## National Grid Yaxley 400kV Substation, Leys Lane, Yaxley IP23 8DX Planning ref: DC/23/05363 - Condition 6 (Surface Water Drainage)

This document has been prepared in response to the refusal to discharge condition 6 (Surface Water Drainage) of planning application reference DC/23/05363, outlined in email correspondence dated 21.11.2024 from Suffolk County Council (SCC).

Reference: 306-006-RP07  
Revision: -

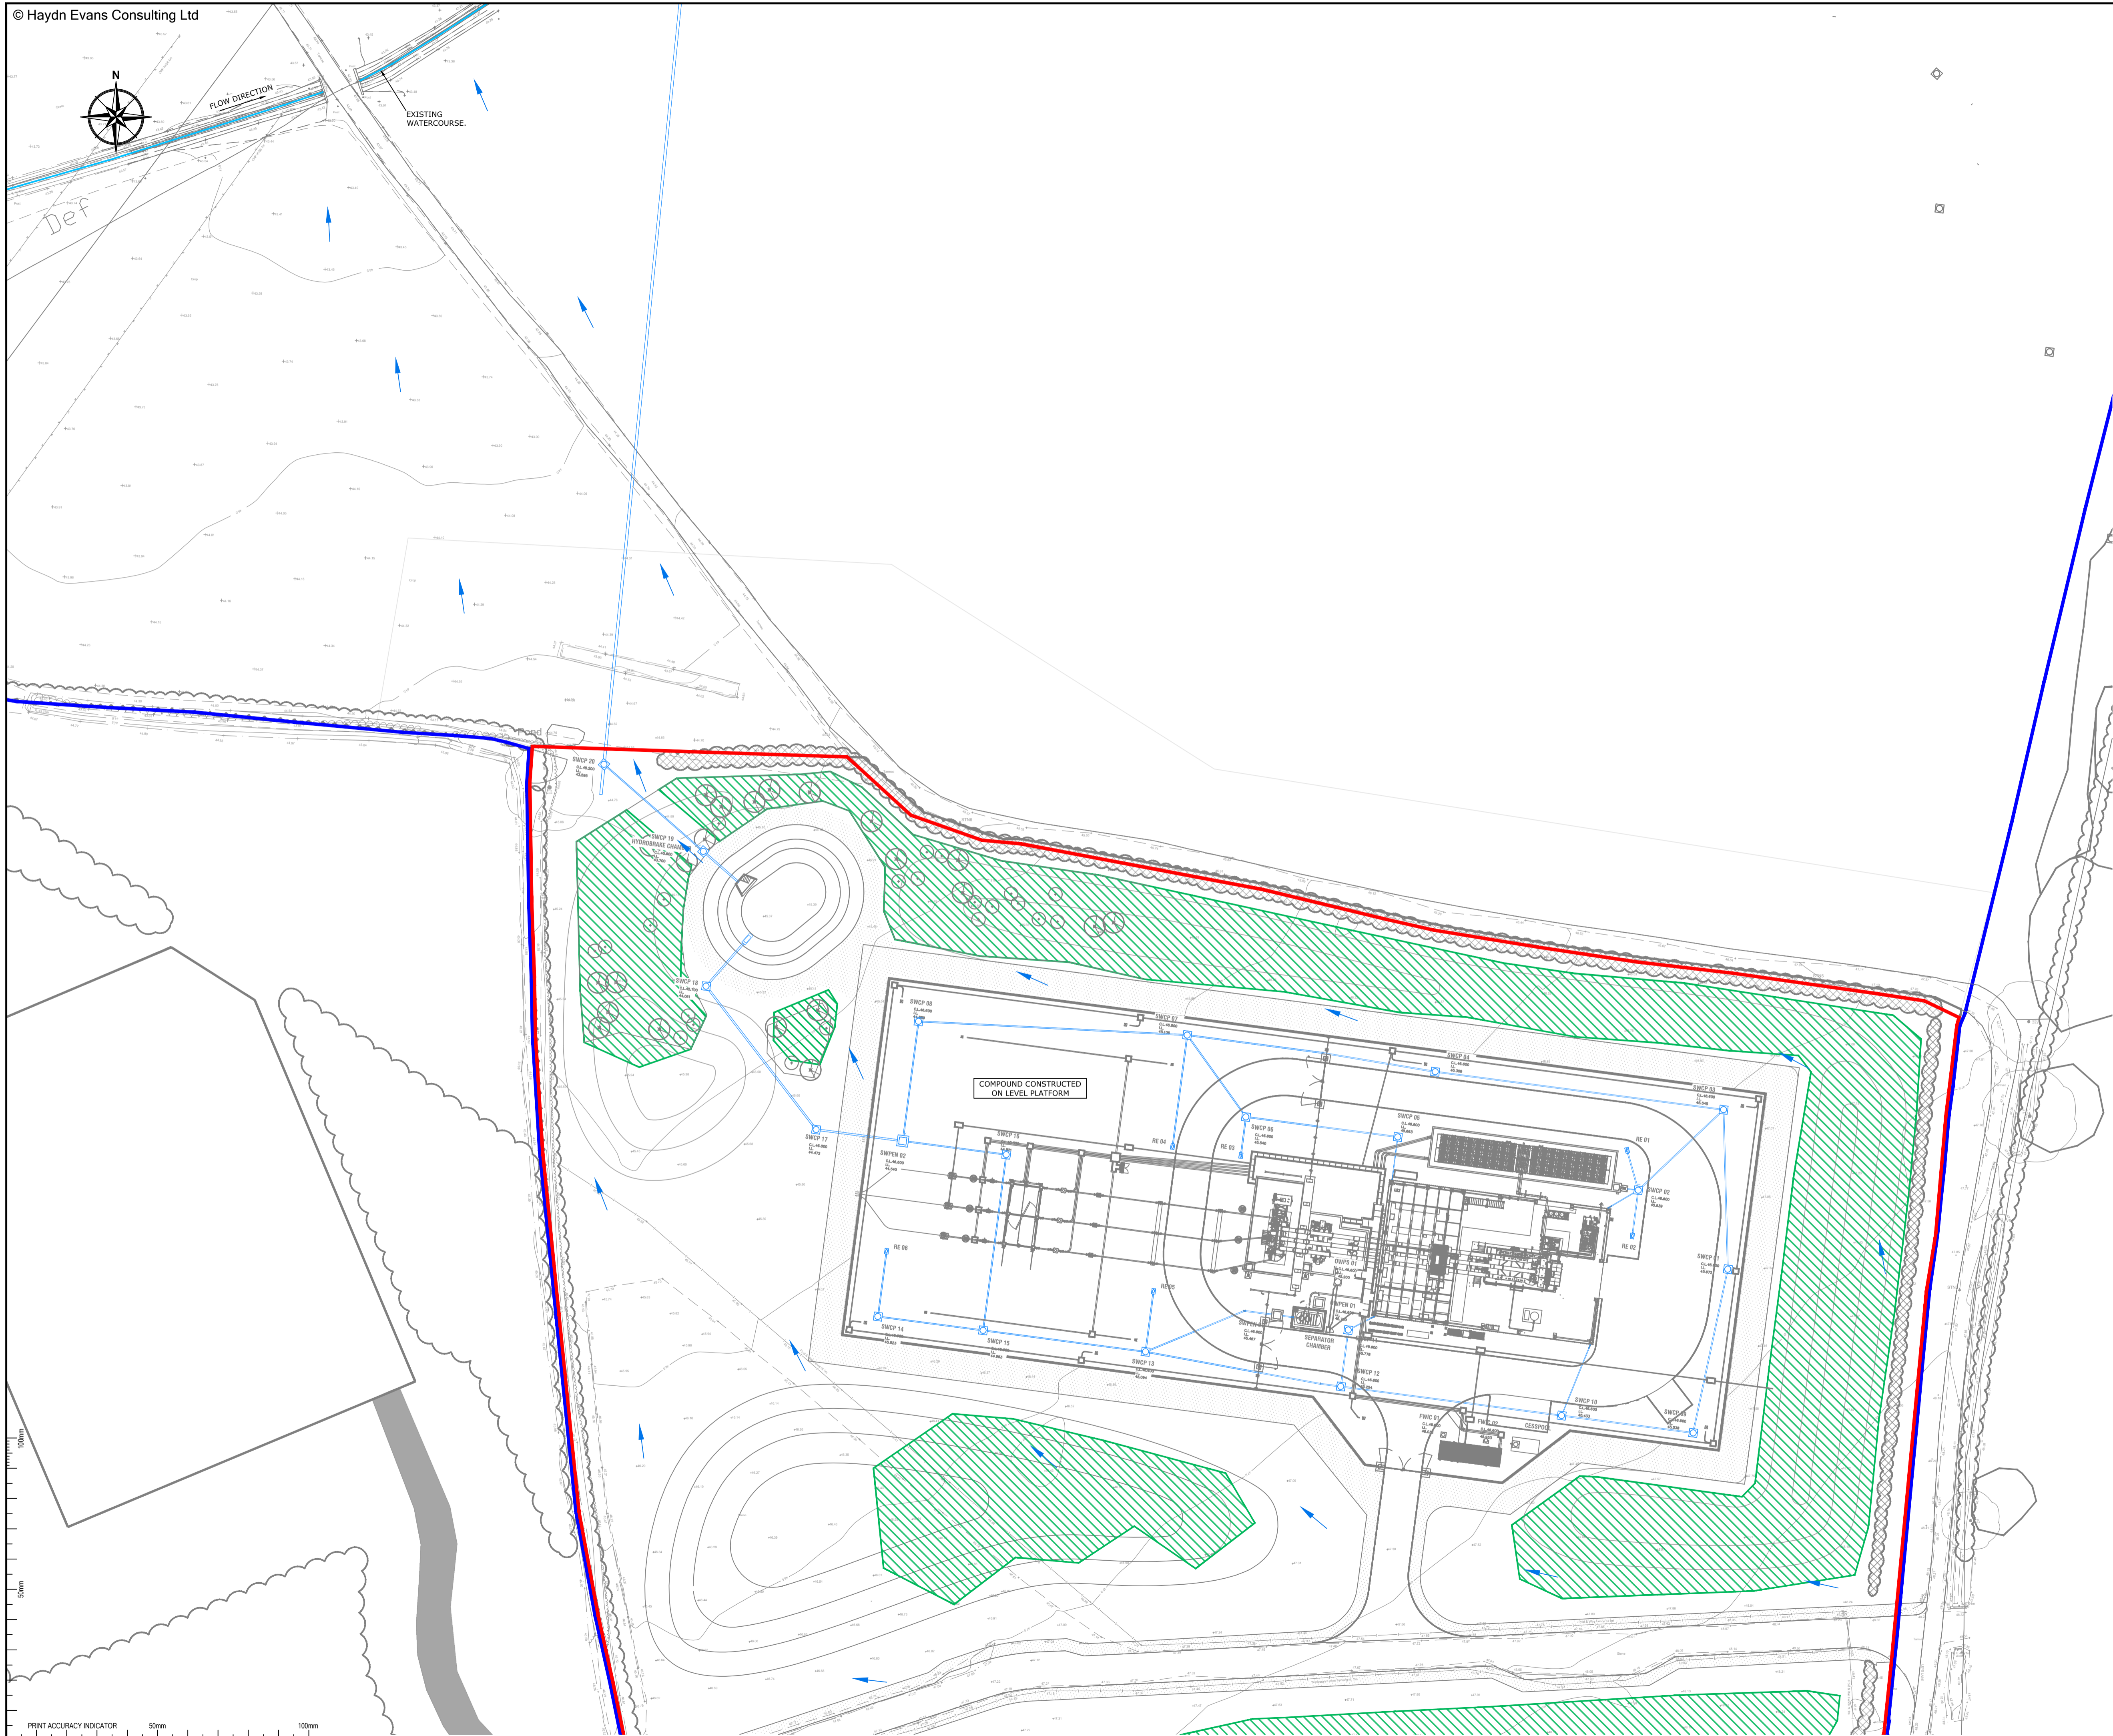
2. *Applicant will need to submit the following documents/information.*
  - a. *Cross section of the attenuation basin, depicting side slopes no greater than 1:4, 1.5m wet/dry benches every 0.6m depth of water, freeboard min 300mm, 3m maintenance strip and indicate depths for 1:2, 1:30 & 1:100+CC rainfall events. Water depth shall be no greater than 1.0m*
  - b. *Flood flow exceedance plan*
  - c. *Management and Maintenance Plan/schedule of the surface water drainage system*

Exceedance flow routes are shown on drawing 306-006-D300, attached.

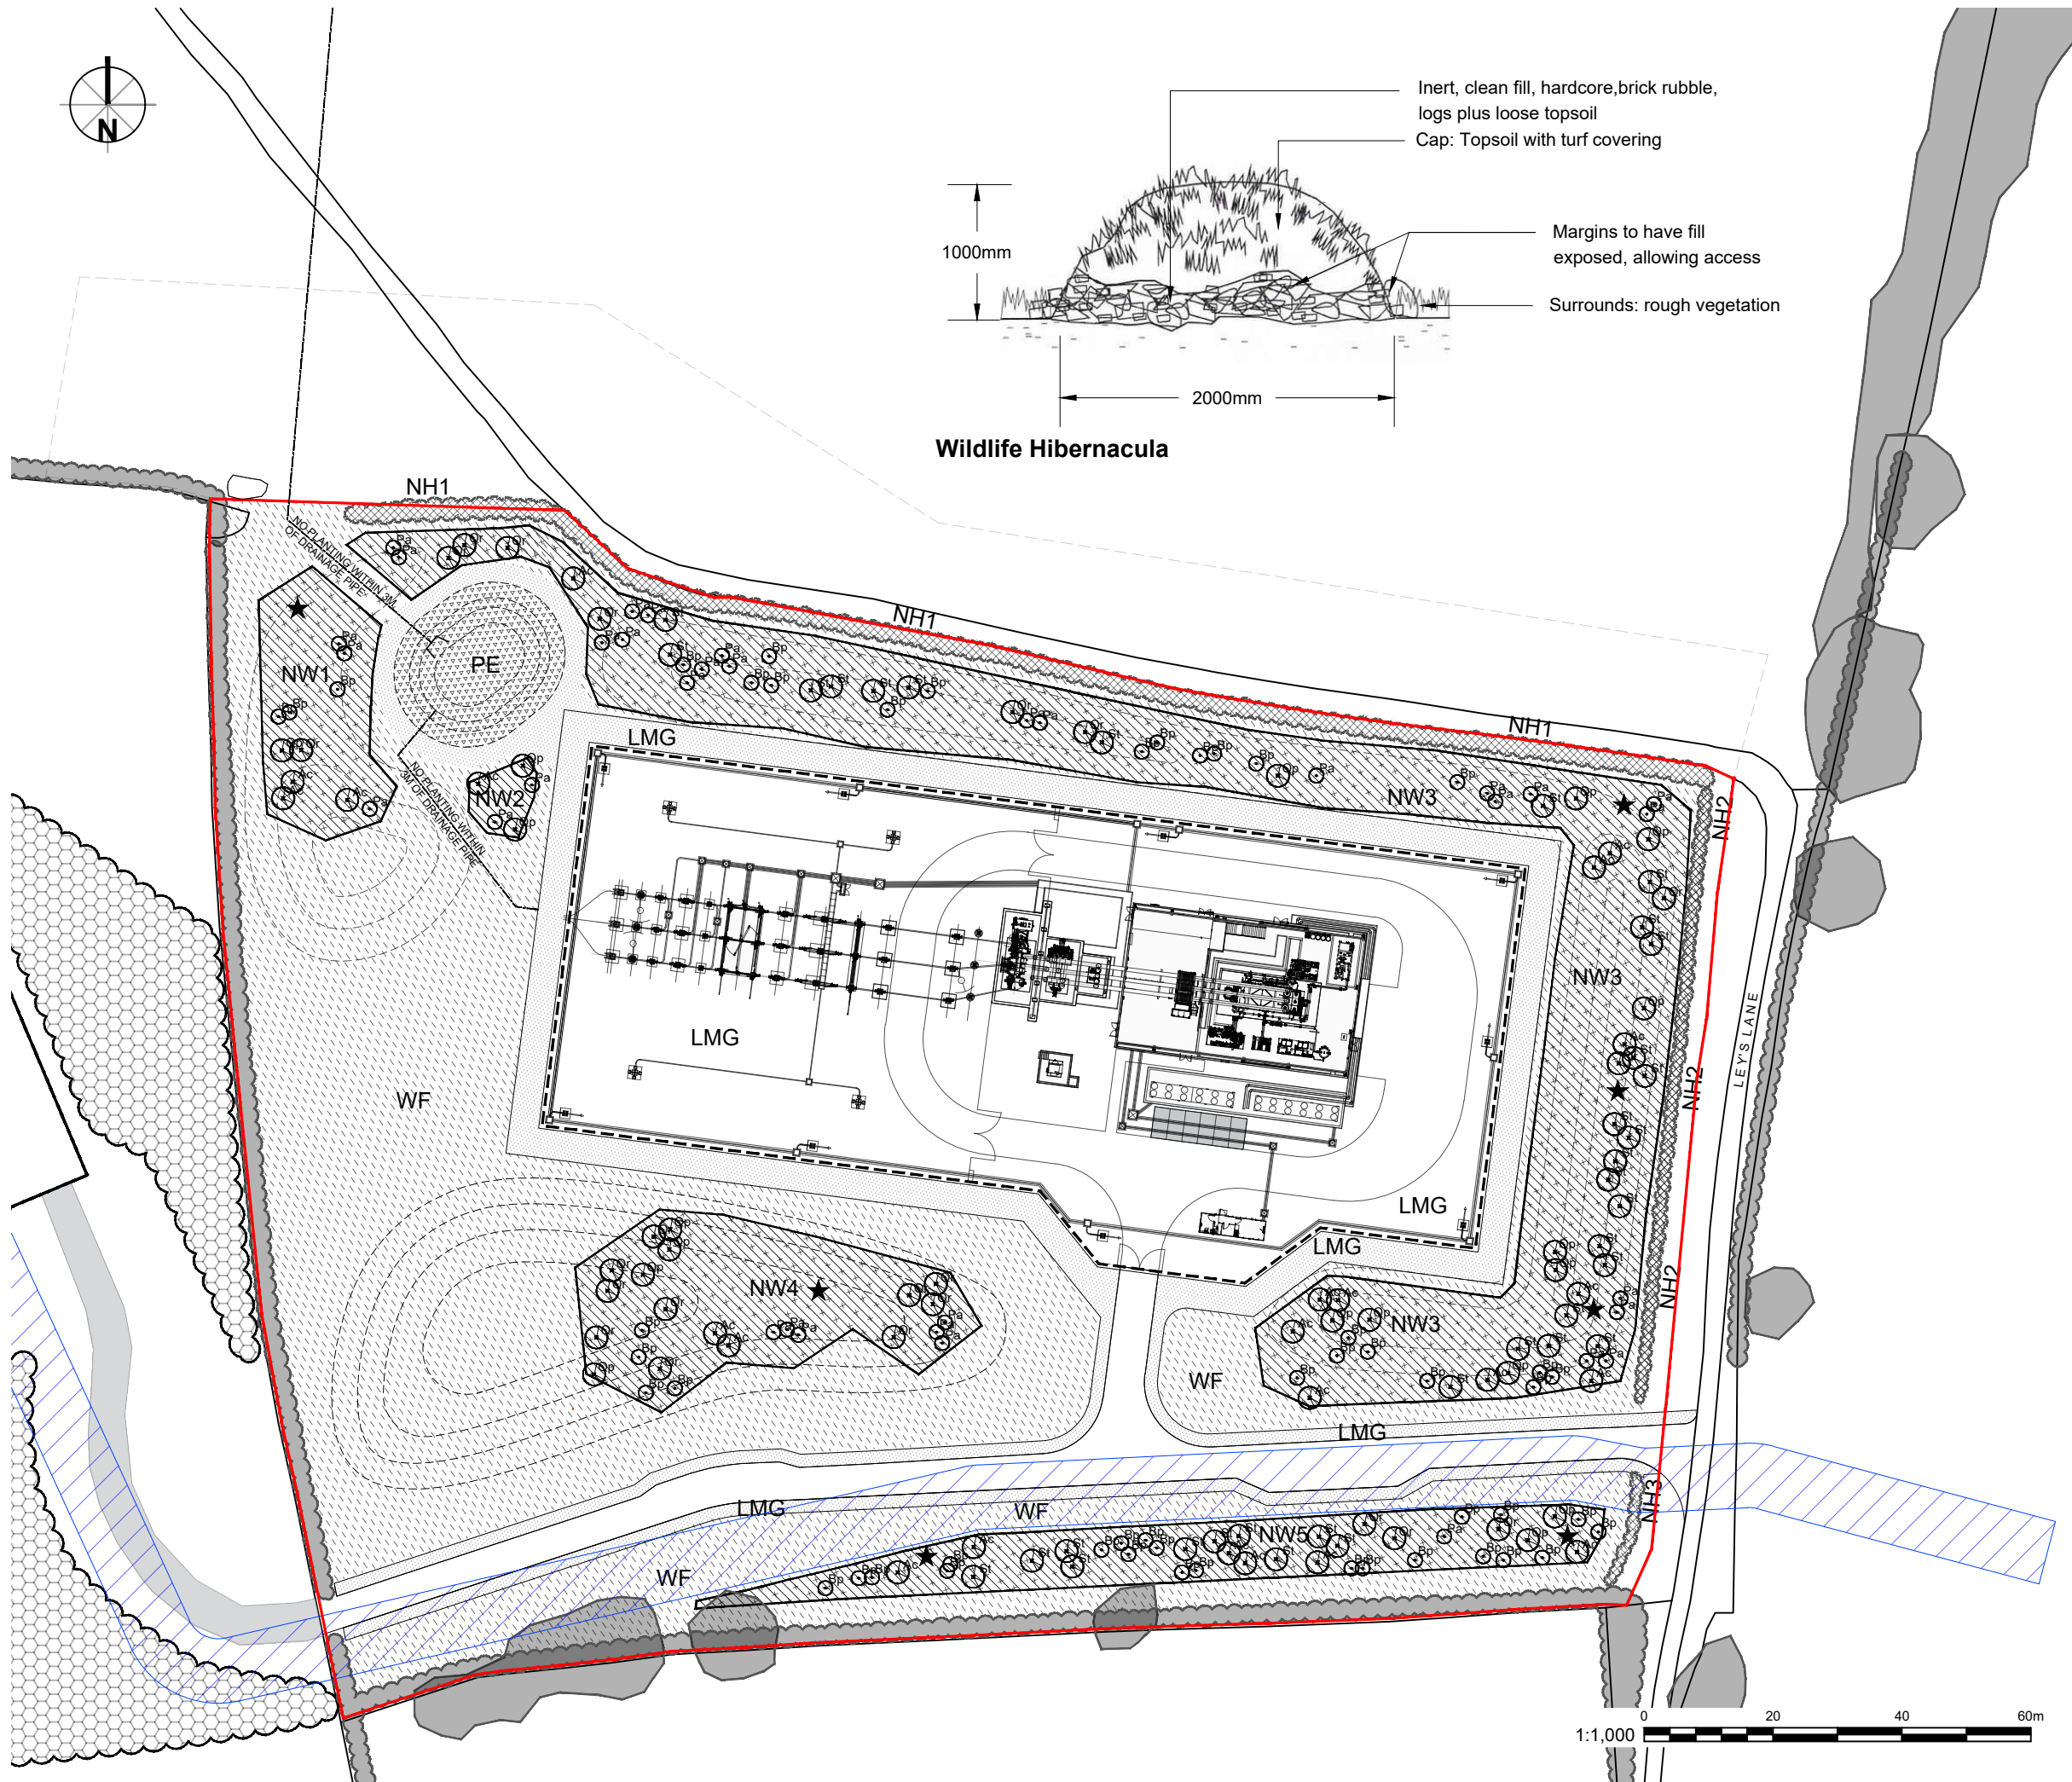
3. *Submit a landscaping plan for the attenuation basin.*

**HE response:** DRaW (UK) Ltd have produced a landscaping plan, see drawing 059-12-01(S73) B attached. The basin is planted with Pond Edge Seed Mix (Emorsgate EP1) which contains 80% grasses, including Bents and Fescues; it is a commercially available mix designed specifically for water bodies/pond margins.
